Planning Officer: Mr F Gardner
Planning Application Ref: Y/33/19/T
Location: Ferndale House, Burndell Road, Yapton, BN18 0HT
Description of works: Fell 1no. sycamore tree
Reasons Given: Risk management

FHplan

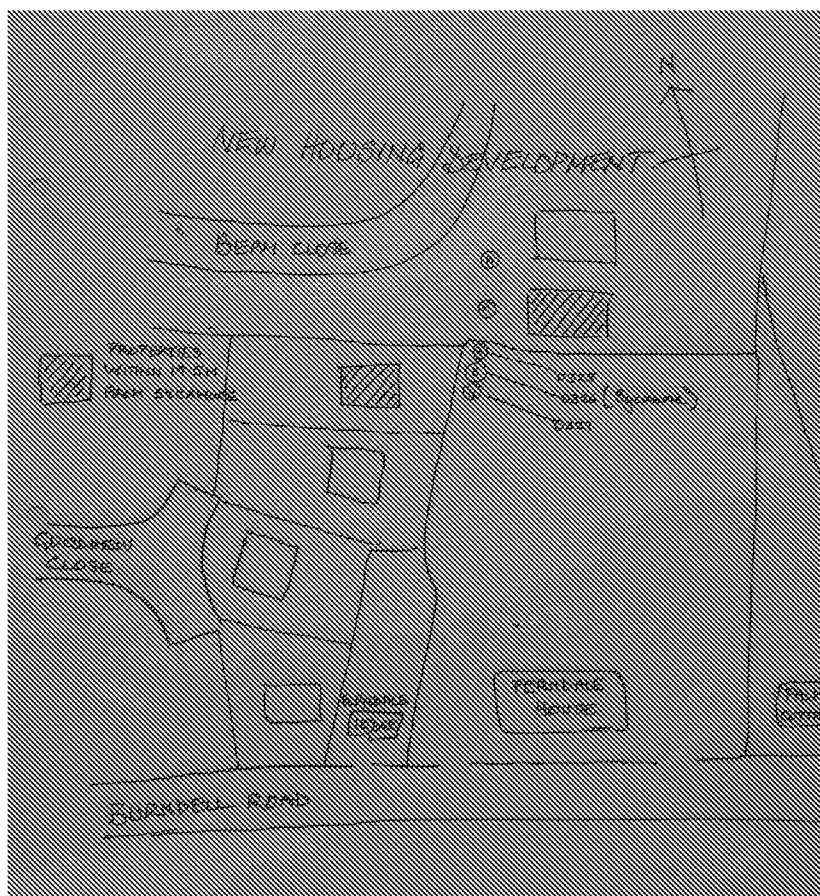
- This tree appears to be outwardly healthy and stable with a relatively unmodified and attractive crown profile. It has landscape value and is both highly visible from numerous properties and to users of the public highway (footway and carriageway).
- It grows between and dominates two mature hornbeam trees; an attractive group benefiting from mutual support and cohesion. Beyond the curtilage of this property the group and especially the sycamore can be viewed as an important constituent of an established line of trees, which both help define the character of the area and represent a significant public amenity.

- This tree provides significant visual amenity and has not been proven to present an unacceptable level of risk for its location, so should be retained.
- This is a long-established tree given adequate room and statutory protection during/in response to - relatively recent residential development; so as to be purposefully retained in harmony with surroundings. The work proposed has not been justified on arboricultural grounds.

- I recommend **REFUSAL** for this application.
